From: Graham Evans
Sent: 21 March 2011 15:17
To: Planning.Responses
Subject: FW: Planning Consultation on: LU/43/11/

APPLICATION NO: LU/43/11/

Registered: 07-MAR-11
Site Address: 2 Norfolk House Beach Road Littlehampton BN17 5HQ

Description of Works: Use of premises as an Indian tandoori restaurant with new extract system & disabled wc

Proposed Plan

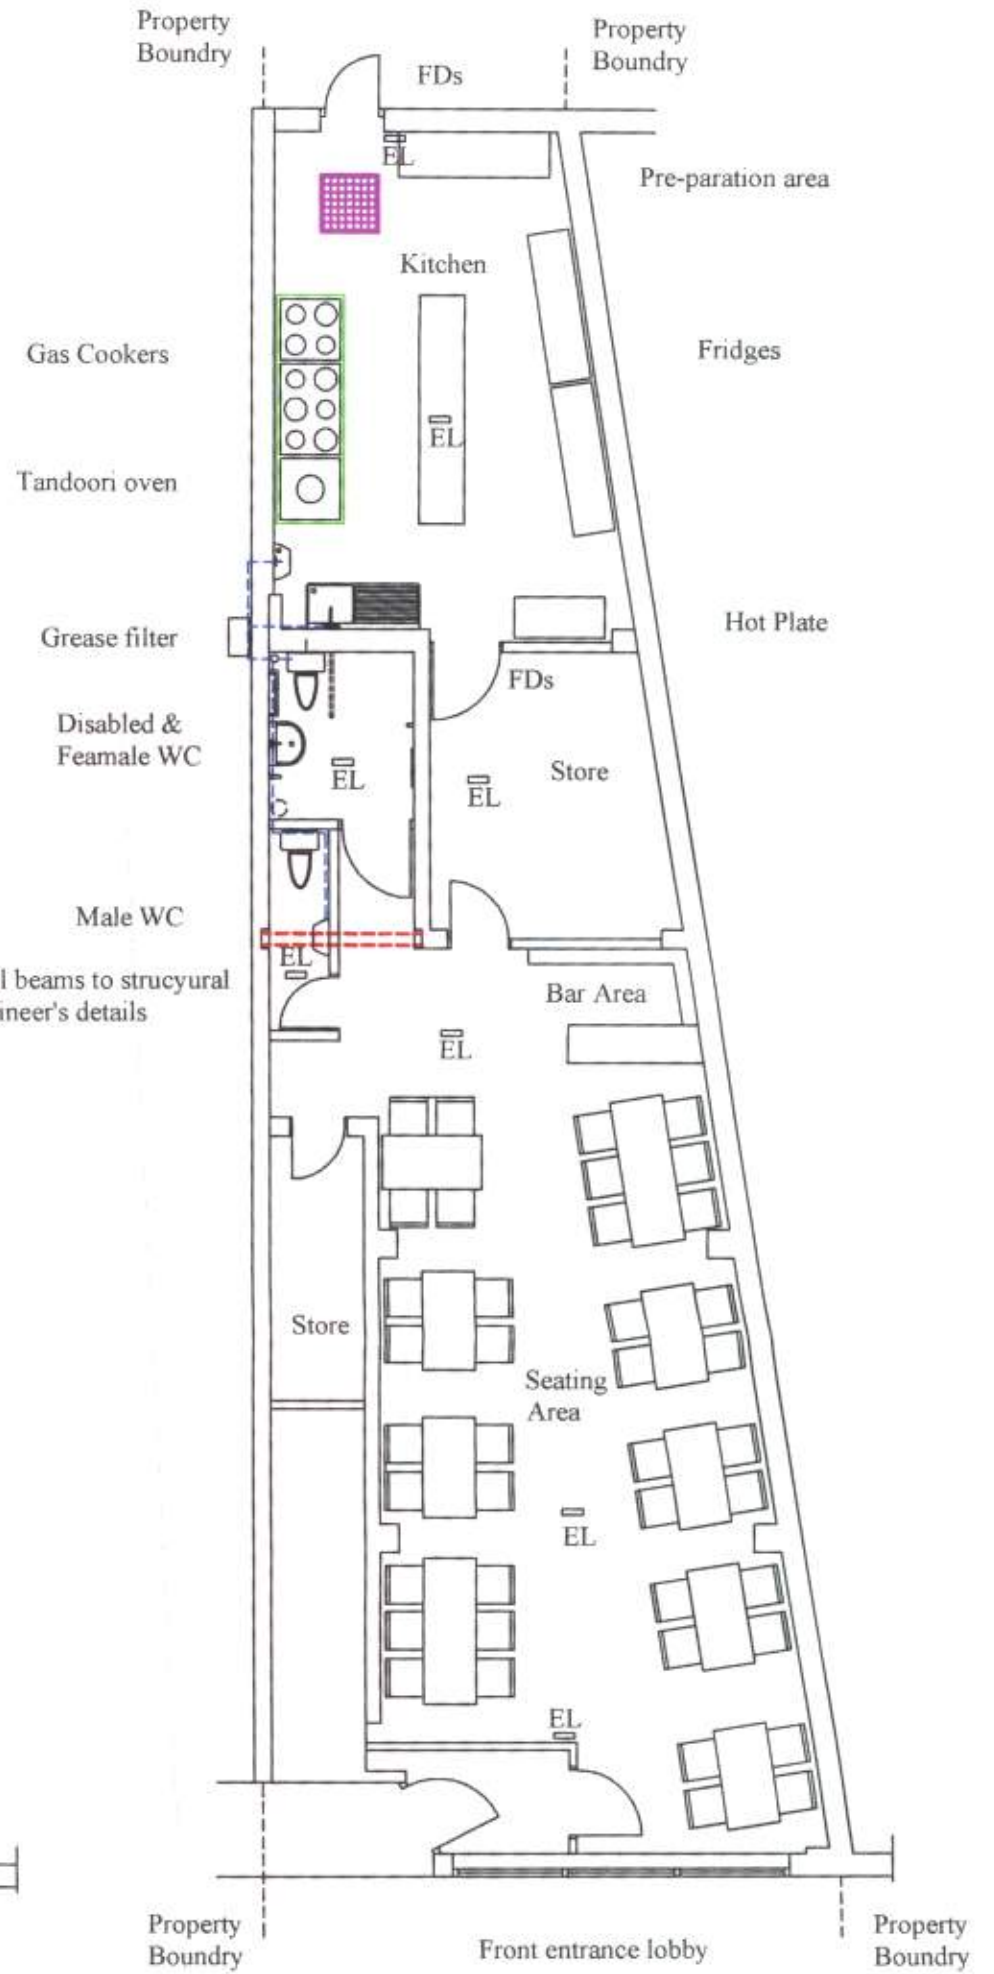
The proposed internal layout is not appropriate for a commercial food premises, in that there is no intervening ventilated lobby to the customer toilets, which opens directly into a room where customers are to consume food. A small reduction to the numbers of customer seating may be necessary in order to accommodate these changes.

The proposed layout of the rear kitchen, adjoining storeroom and bar area requires review in order to ensure prepared/cooked foods from the kitchen are not conveyed thro' a storeroom, into the dining area. The current wash facilities indicated are inadequate.

**KITCHEN VENTILATION
PROPOSALS**

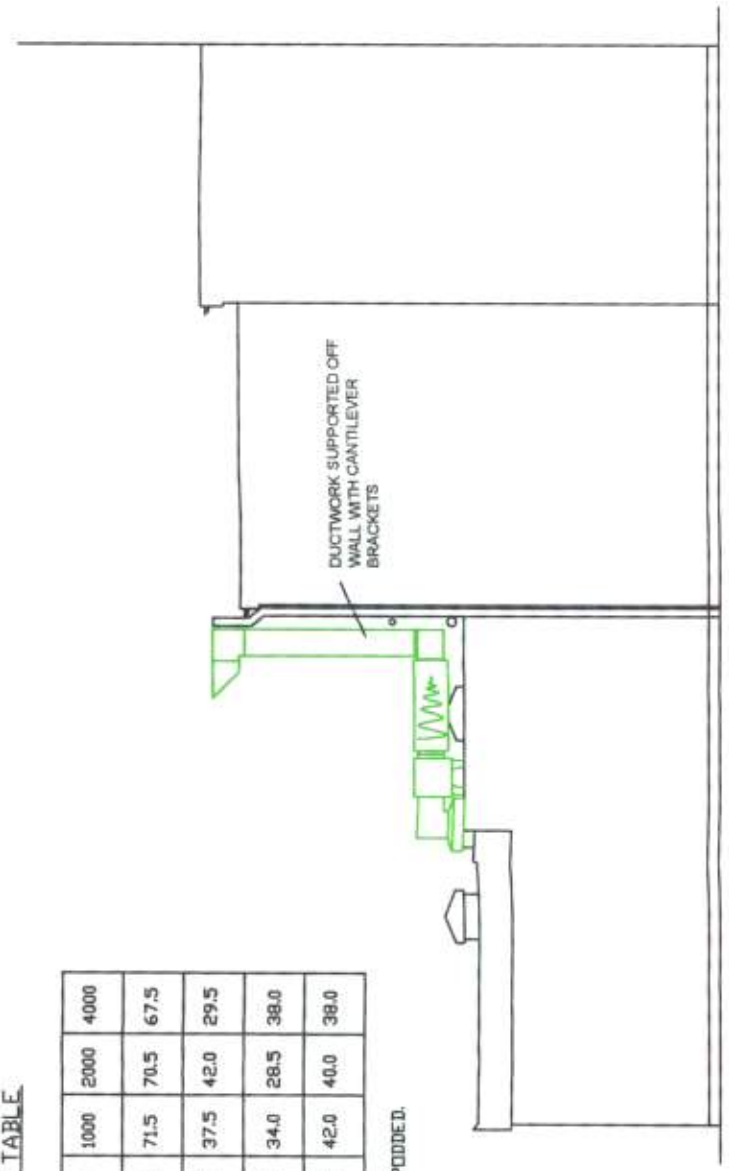
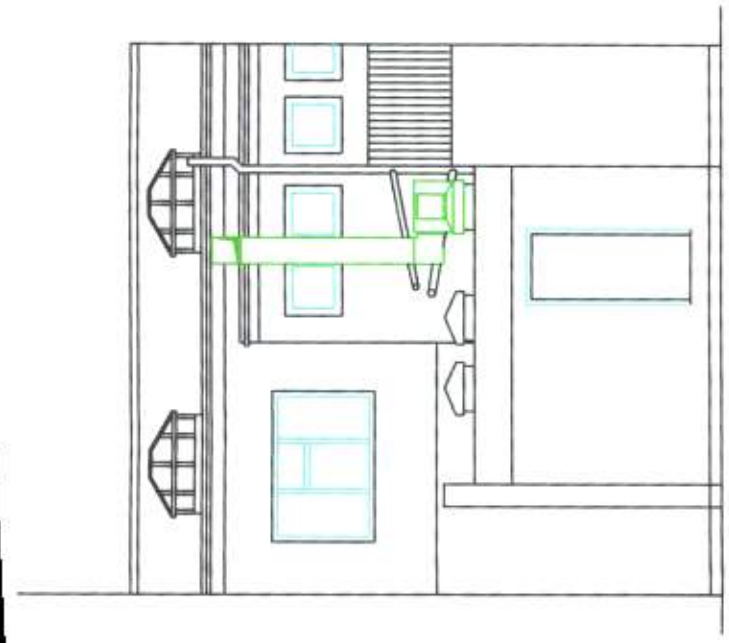
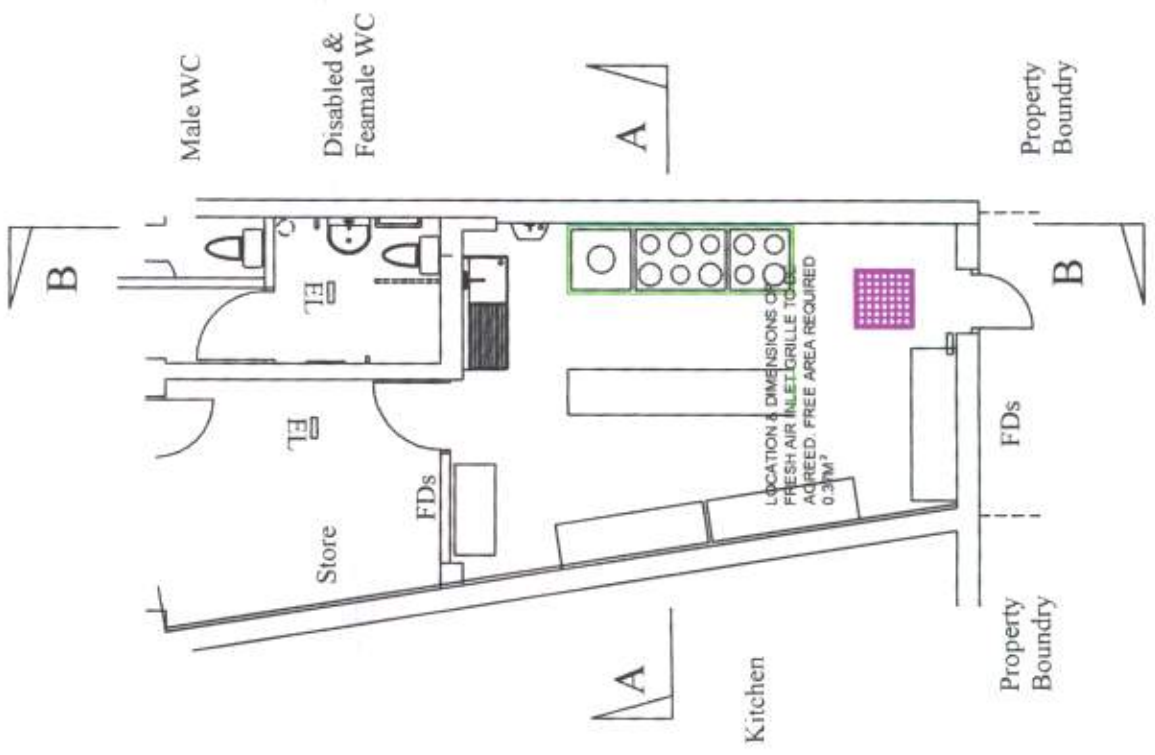
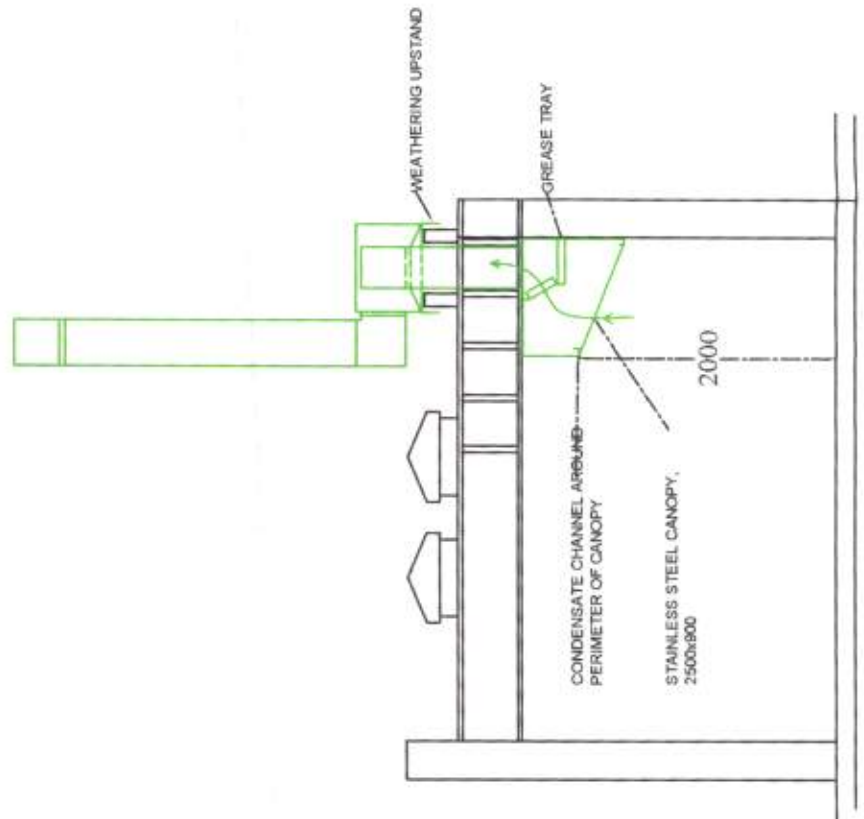
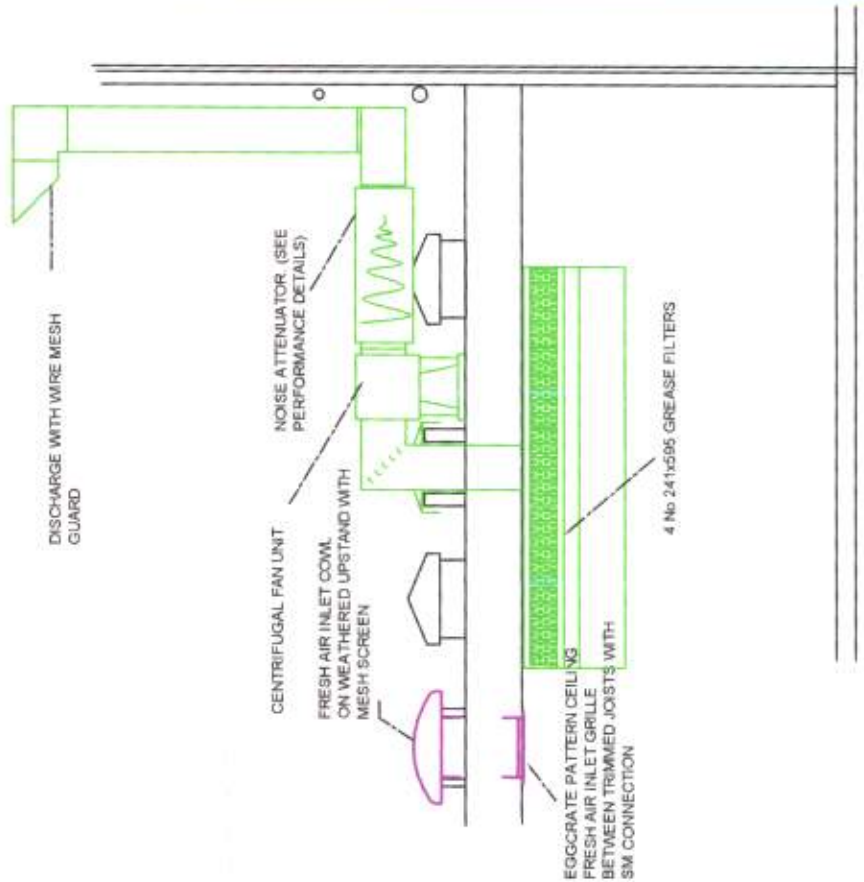
There do not appear to be significant noise sensitive receptors in the immediate vicinity, nevertheless, there is also insufficient information in relation to noise arising from the extract system. The applicant should clarify whether the figures given in the "attenuator performance table" are in dBA or dBLin (octave band levels are normally quoted in dBLin, dBA represents a single numerical value intended to give a subjective evaluation of the impact of sound on the human ear). Please also clarify whether the figures represent sound power levels or sound pressure levels at a given distance from the duct terminal, and confirm whether the intended operating hours for the extract system coincide with premises opening hours.

The proposed extract ventilation system does not include a suitable or effective method of odour control. Given the proposed nature and style of the foods to be prepared and cooked on these premises, there is a serious risk of odour nuisance to surrounding properties. The applicant must provide a method of odour control, with reference to the Defra guidance, to ensure the discharged odours are controlled and minimised, and not excessive to give rise to odour nuisance. EHAIR1
 I would recommend also that the stack terminal discharge design was changed to a 'Vertical Discharge' and not the proposed angled discharge.
